From: Samantha Legg <Samantha.Legg@lincolnshire.gov.uk>
Sent: 29 December 2025 12:14
To: _planningadvice
Subject: FAO - Sam Dewer re. H16-0692-25

Following the re-consultation for the above application and our interim comments.

Although they have largely addressed our previous concerns regarding the highway improvements, the comments below are to be addressed:

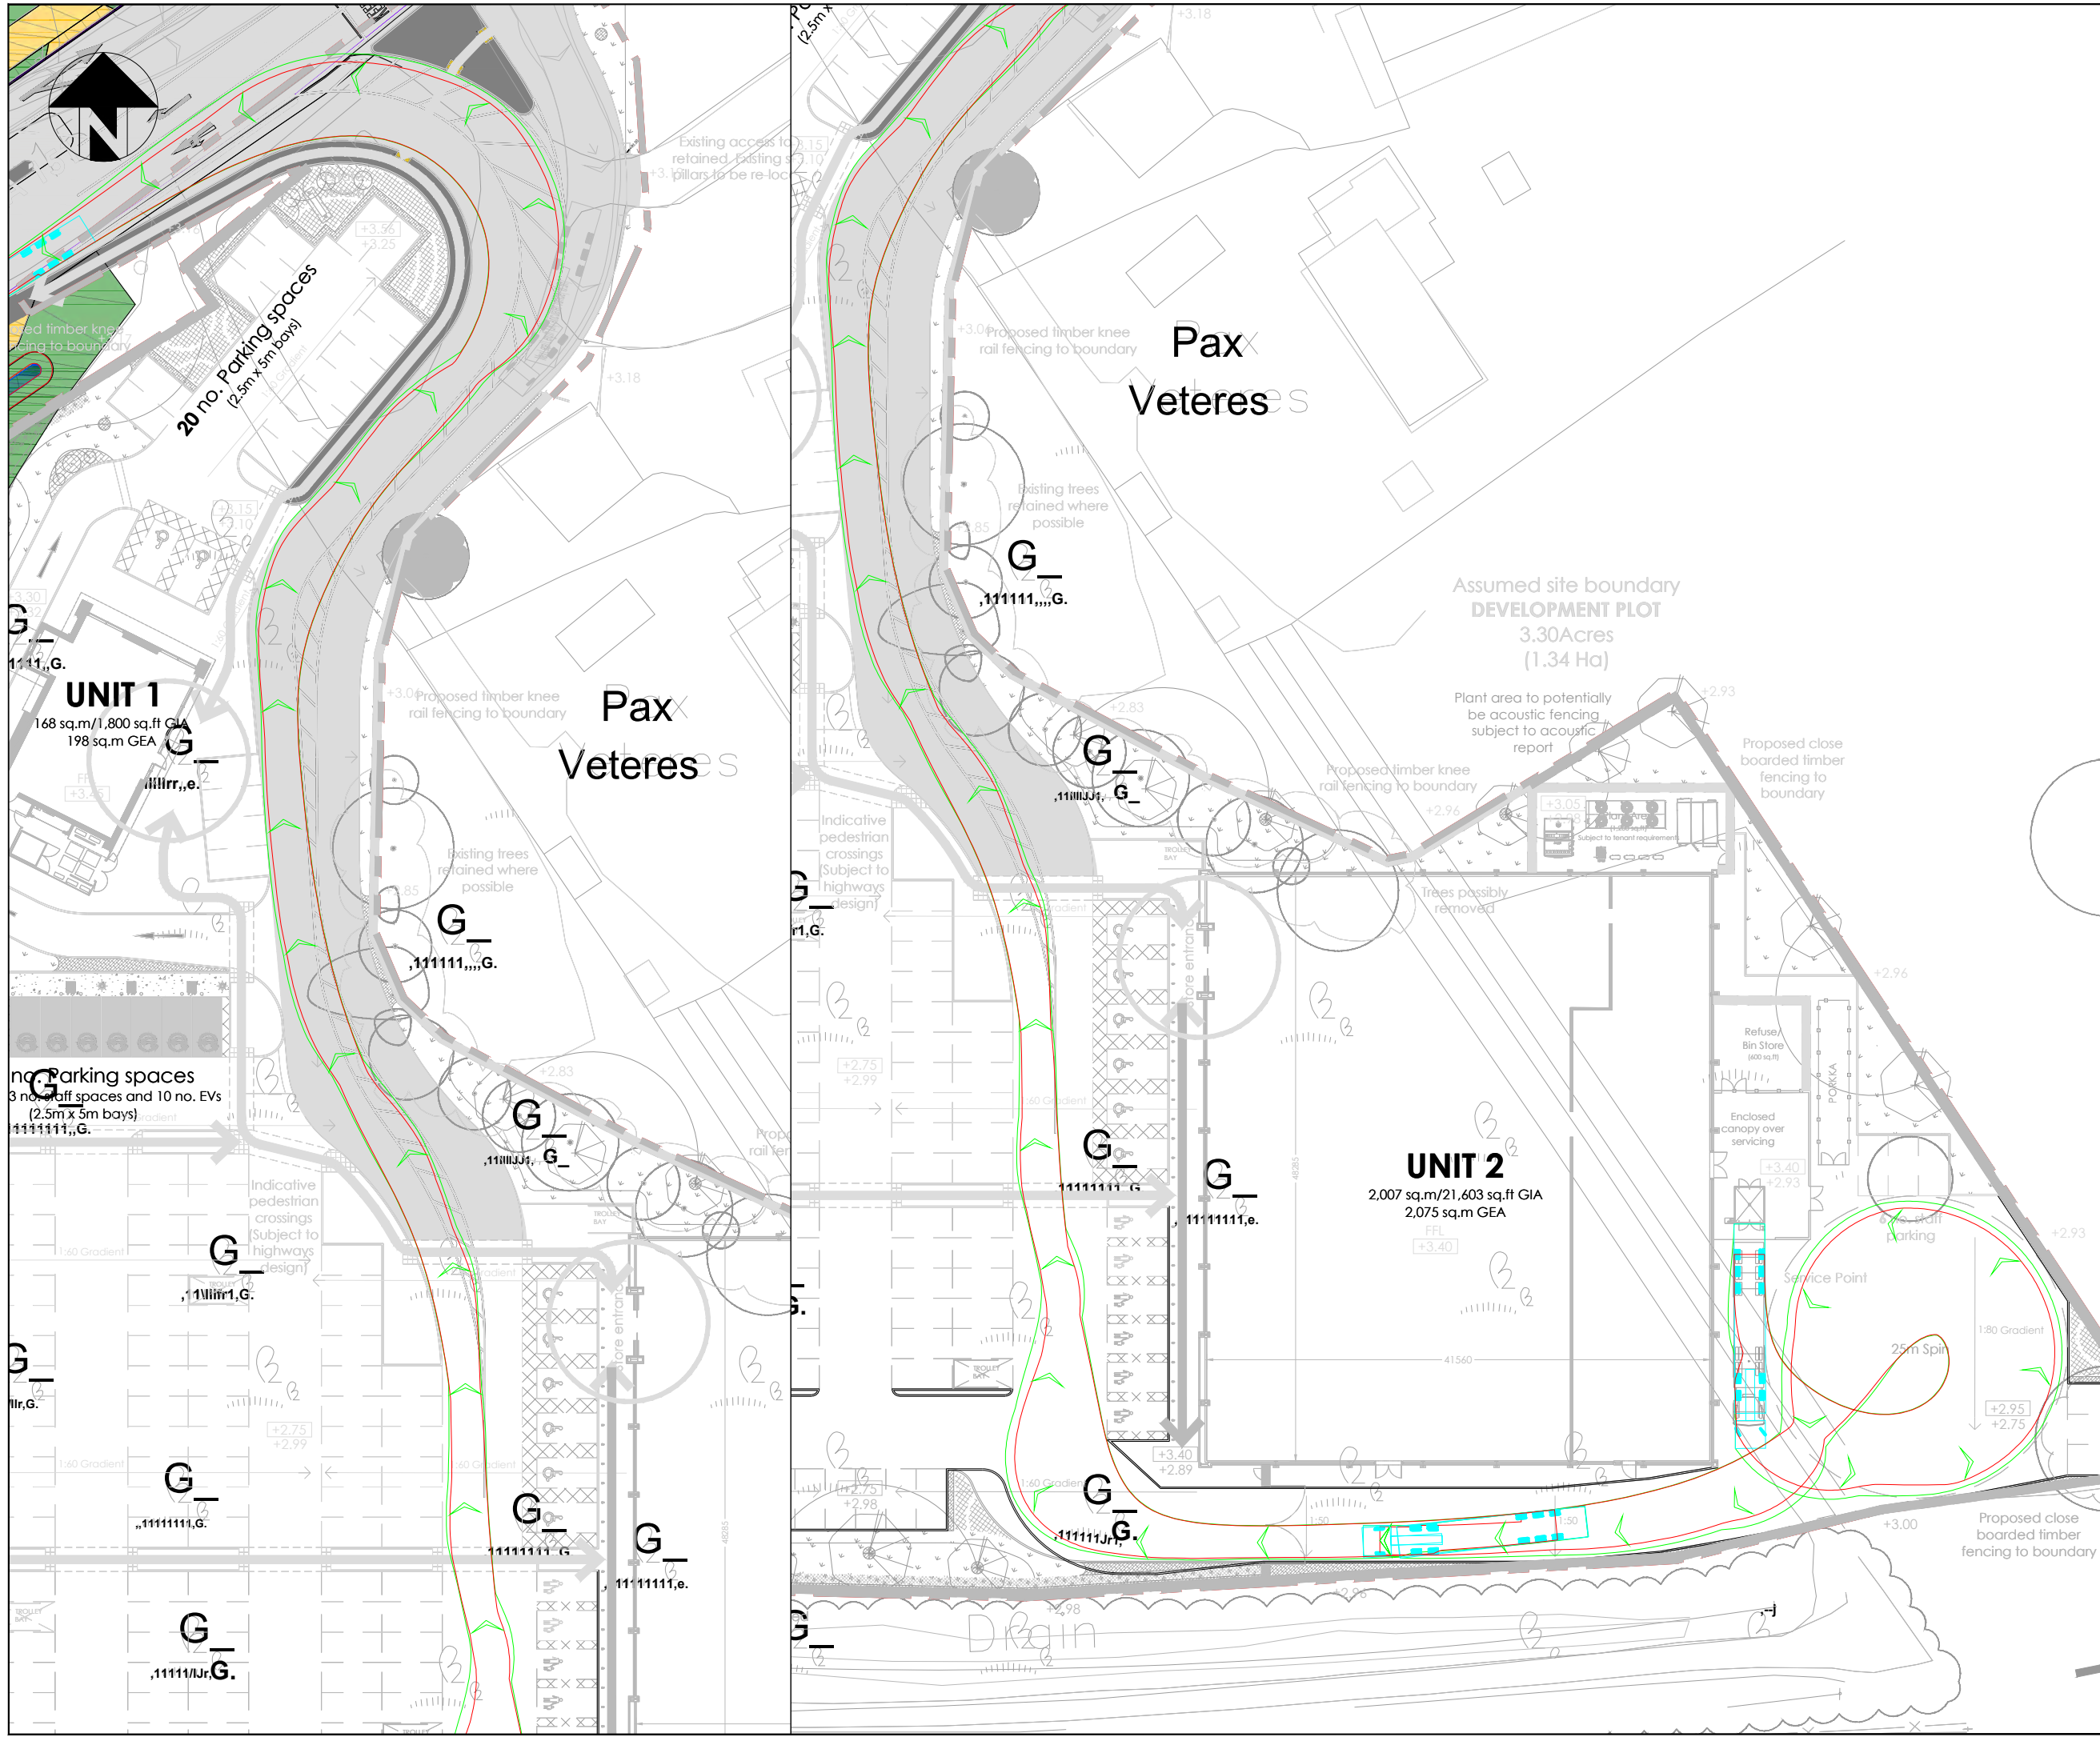
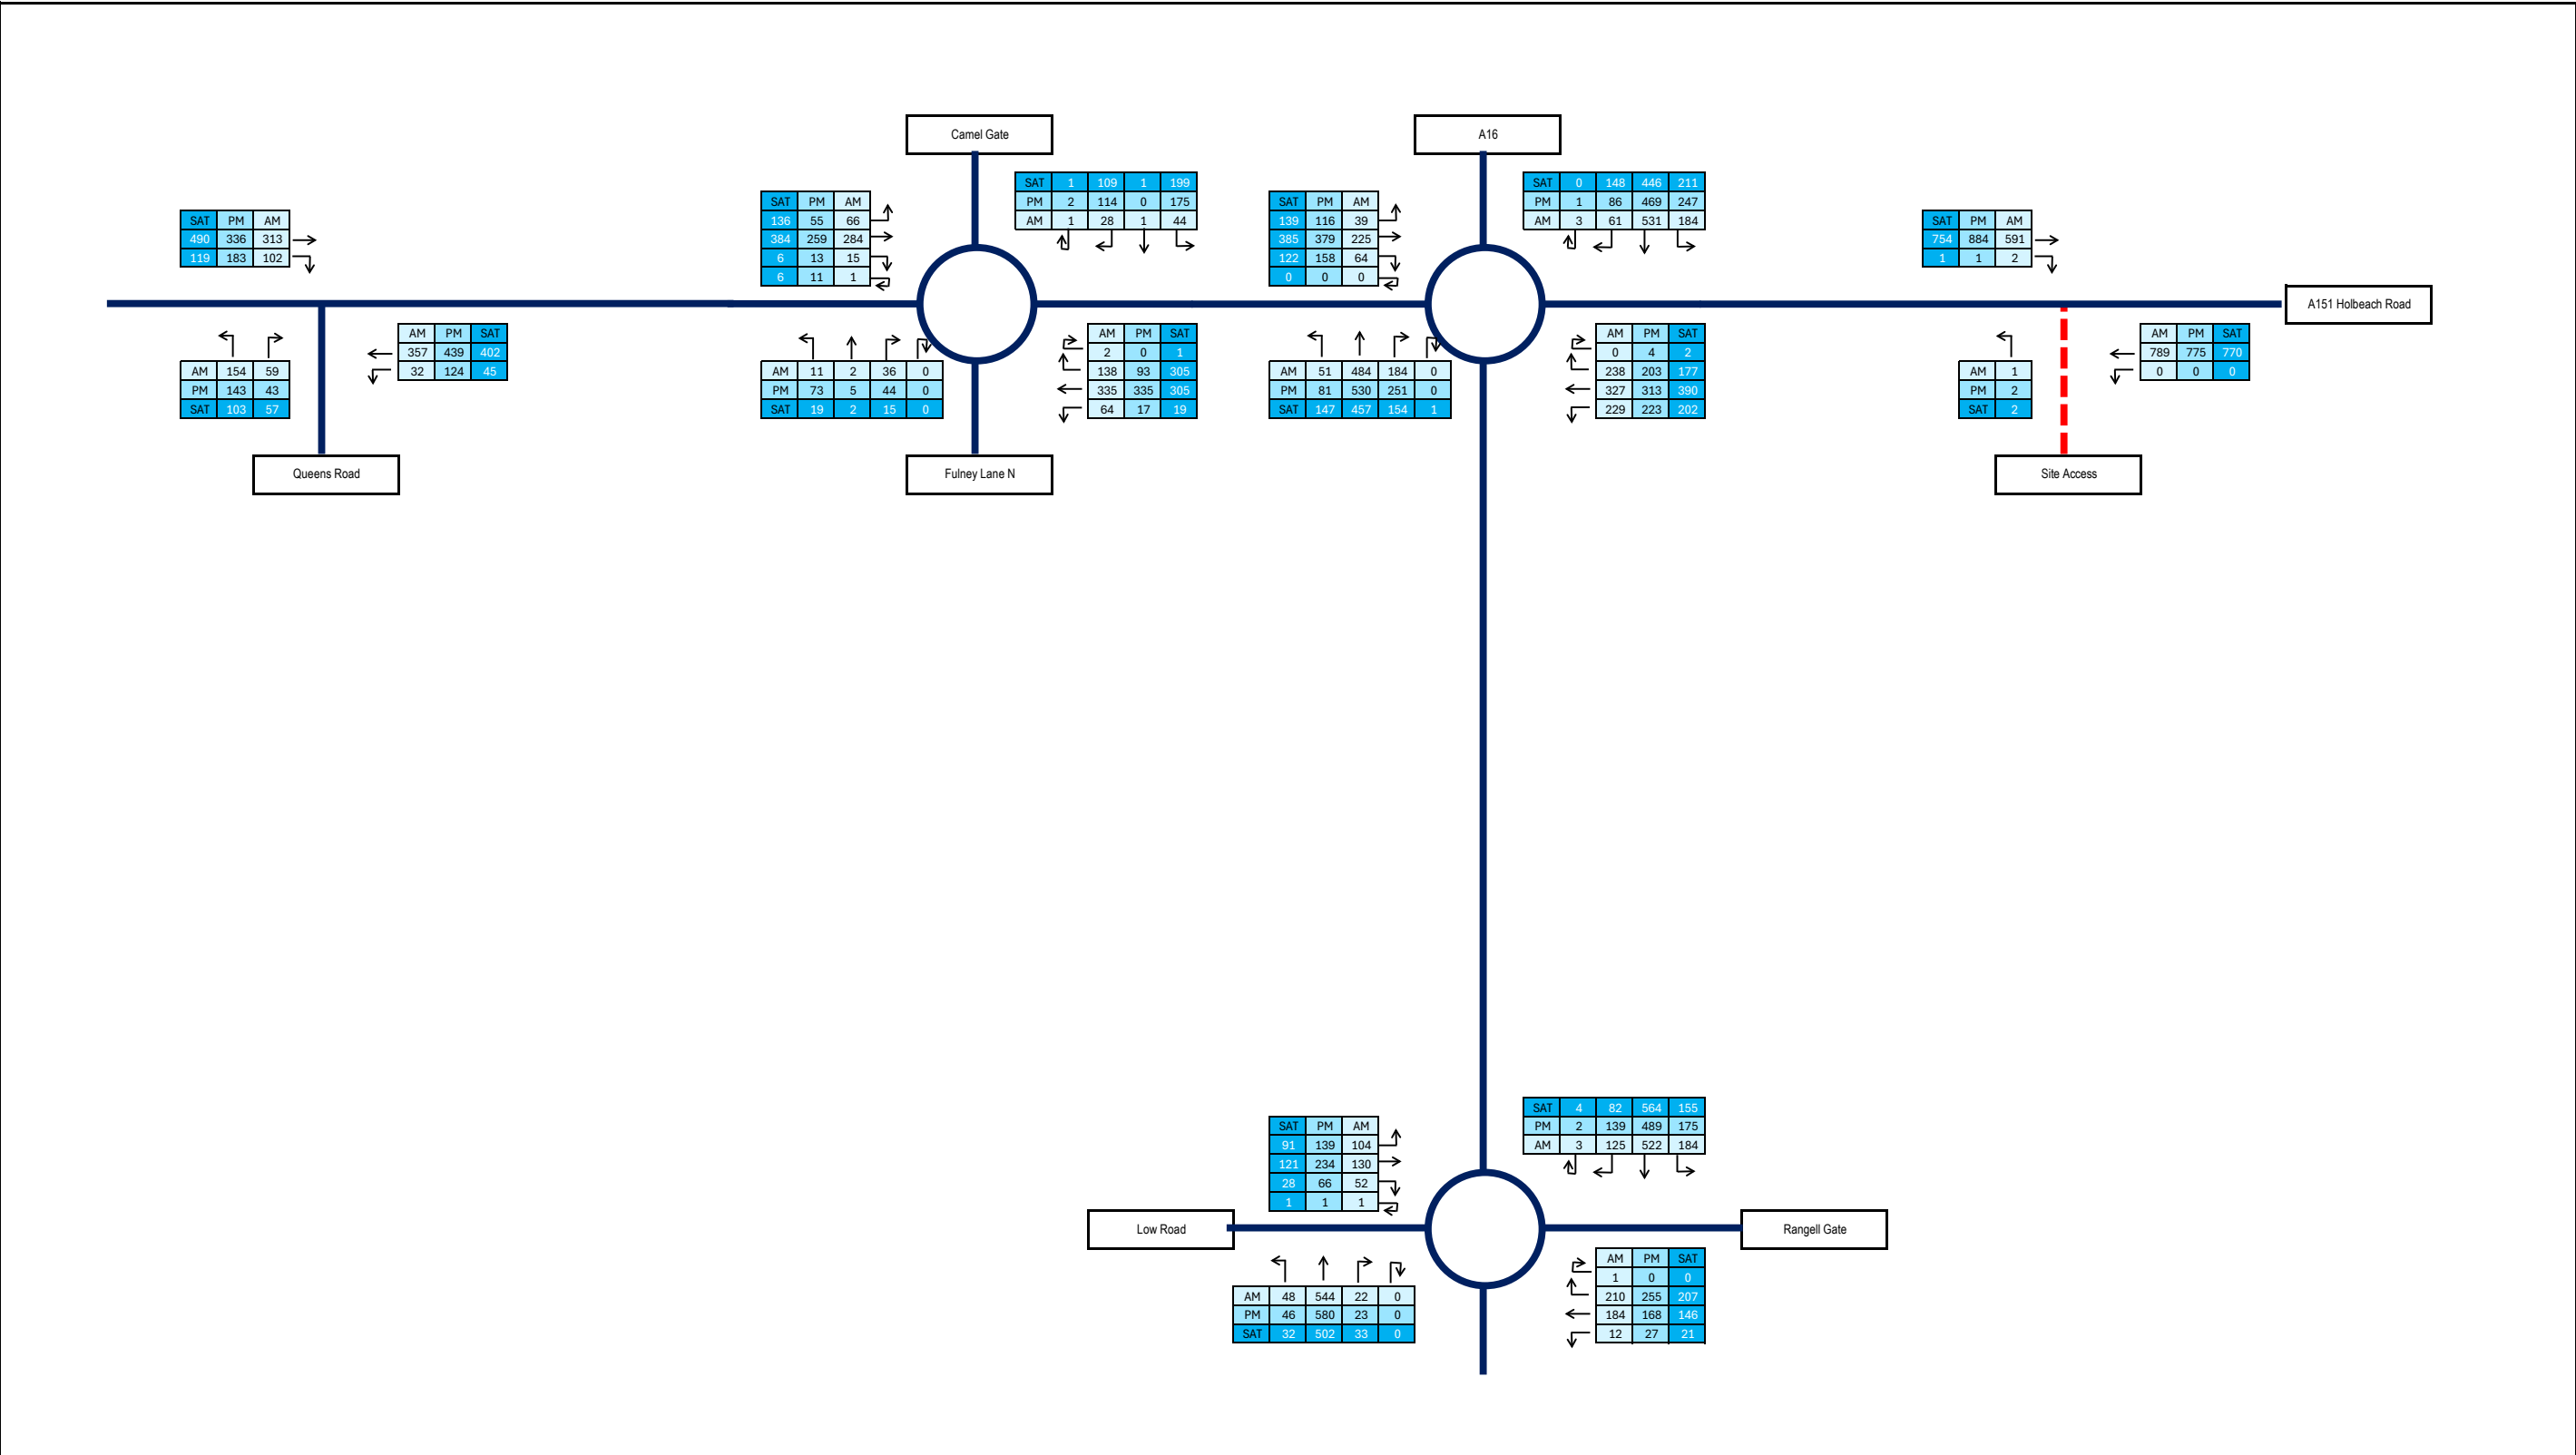
The Transport Assessment does not address safety and the accident data detailed is out of date. Concerns internally with queuing – particularly with it being a Drive Thru and how they operate. There should be a right turn lane internally to the Coffee Drive Thru so that queues internally do not back up into the highway. THIS HAS NOT BEEN ADDRESSED - If people are waiting to enter the Drive thru on the access road, then vehicles will not be able to access the foodstore hence why the drive thru needs its own right turn lane.
